Recommendation Report for Planning Permission for Works or Extension to a Dwelling

REF NO: FG/193/21/HH

LOCATION: 5 Colindale Road
Ferring
BN12 5JF

PROPOSAL: Two storey side extension & ground floor front extension.

SECTION A-A
1:50

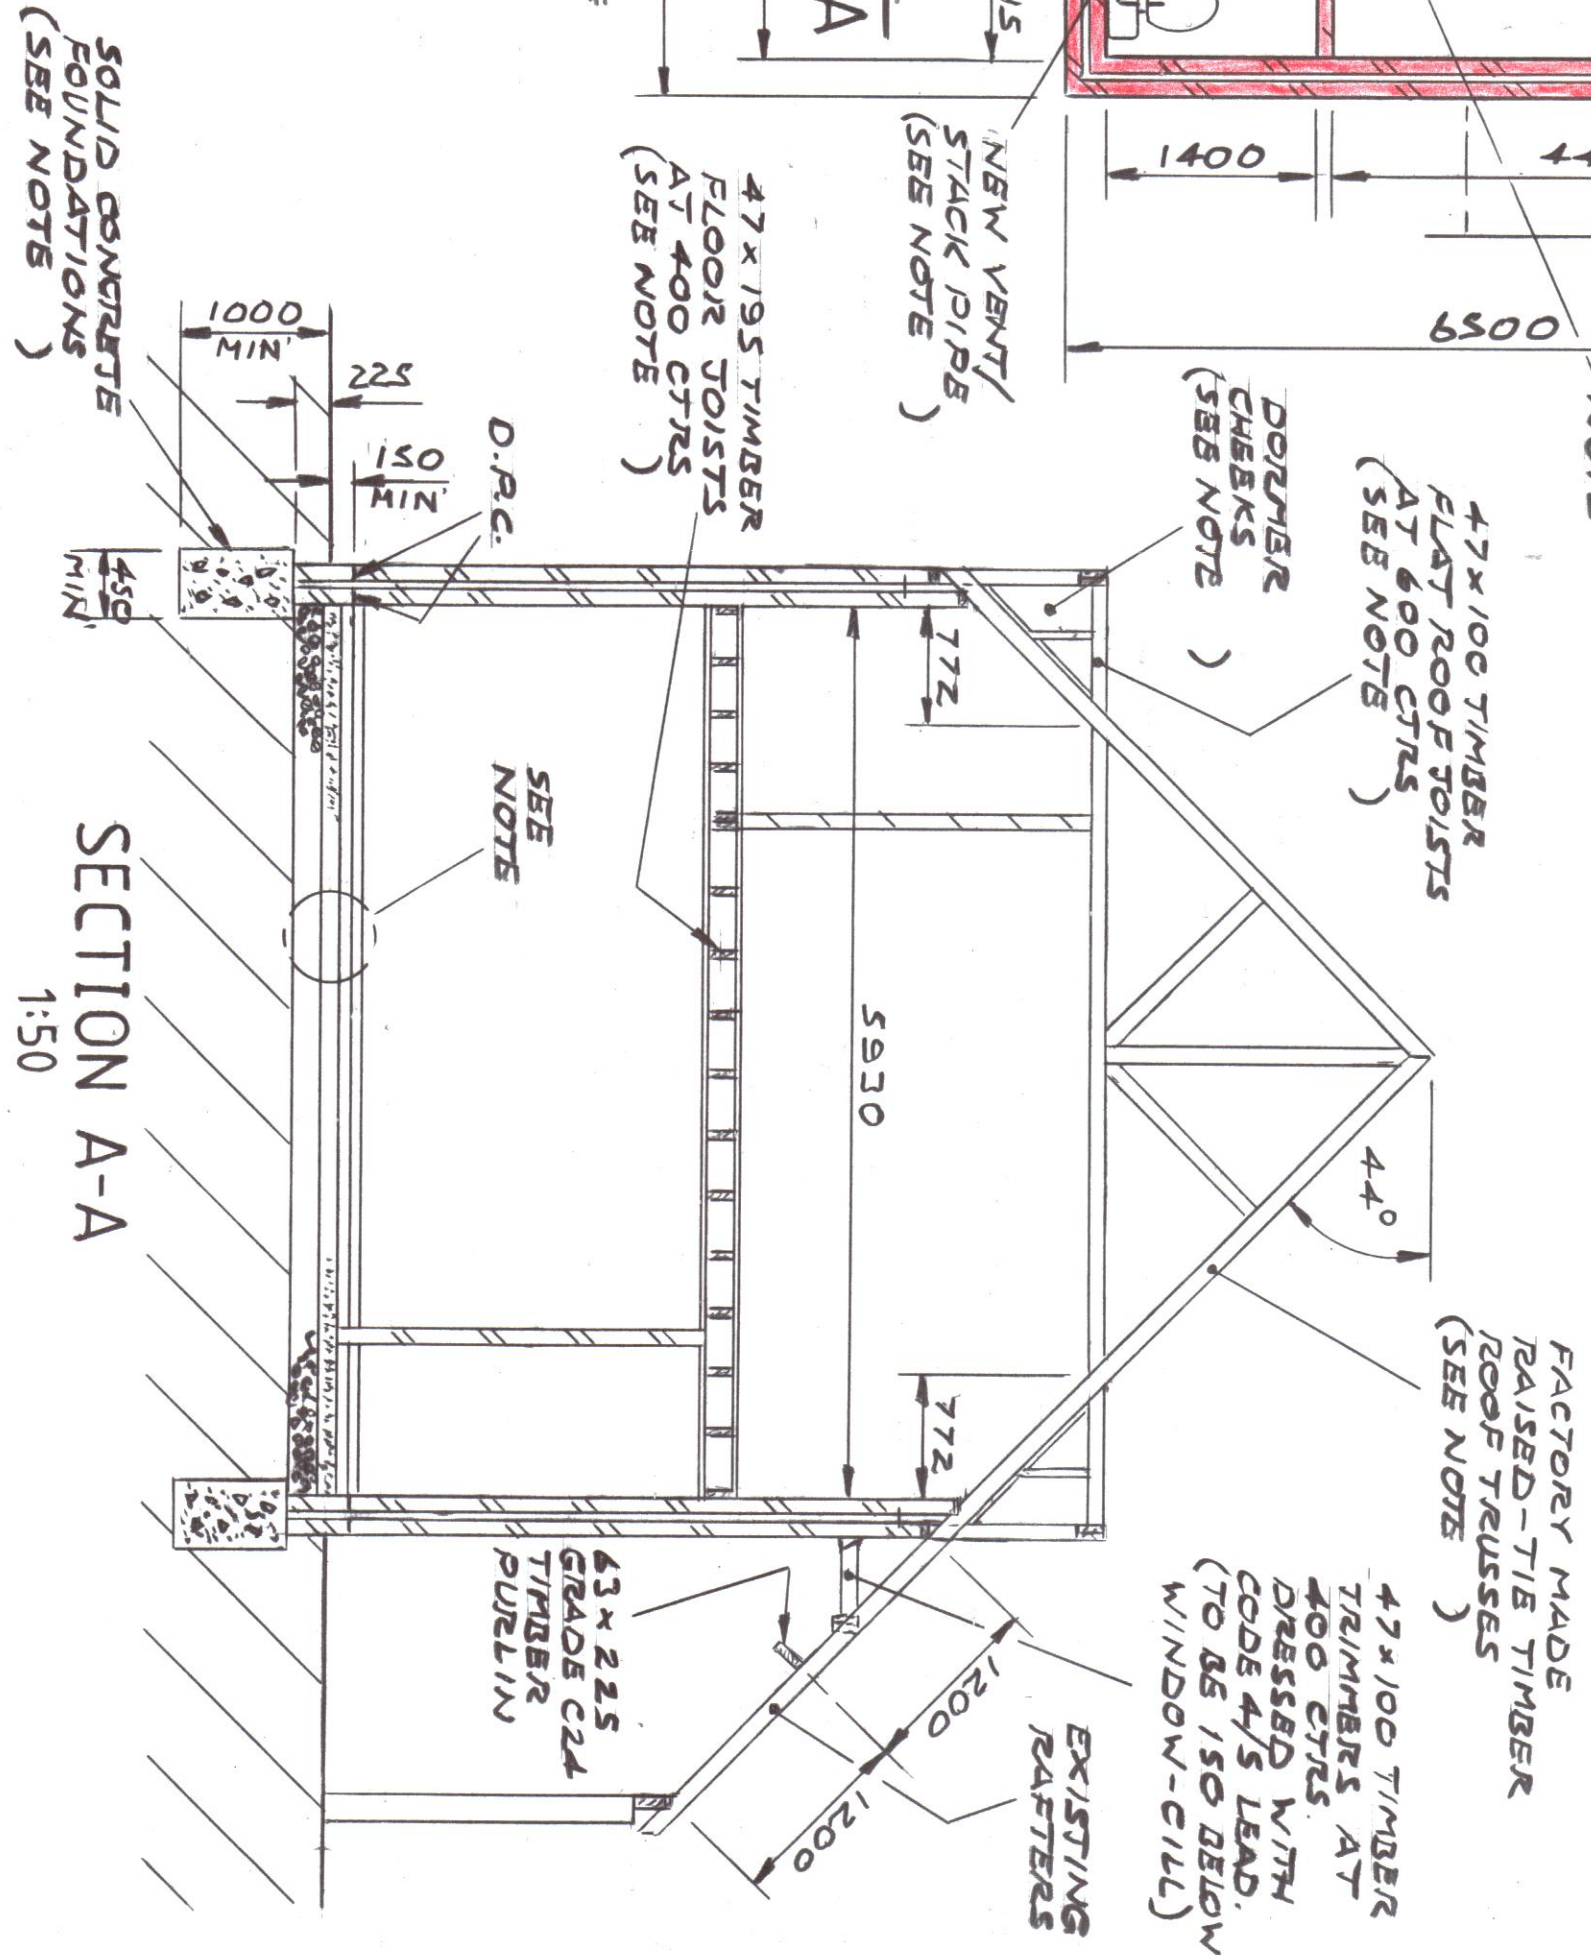
The proposed two storey side extension increases the height of the existing ground floor garage roof from approx. 4.9m to a height of approx. 7m. The peak of this proposed roof height increase is lower than that of the existing peak of the host dwelling. Furthermore, the proposed rear roof slope also matches the existing pitch of the host dwelling. The proposed side extension also projects approx. 2.5m to the rear of the existing garage. The scale of the proposed side extension is modest. The host dwelling has an existing ground floor single storey garage with a tall pitched roof. This side extension is sympathetic, visually integrated and subservient to the host dwelling in terms of form, scale and sitting. The proposed side extension does not cause significant adverse harm to street scene or surrounding character of area so complies with policy D DM1 and D DM4 of the Arun Local Plan.
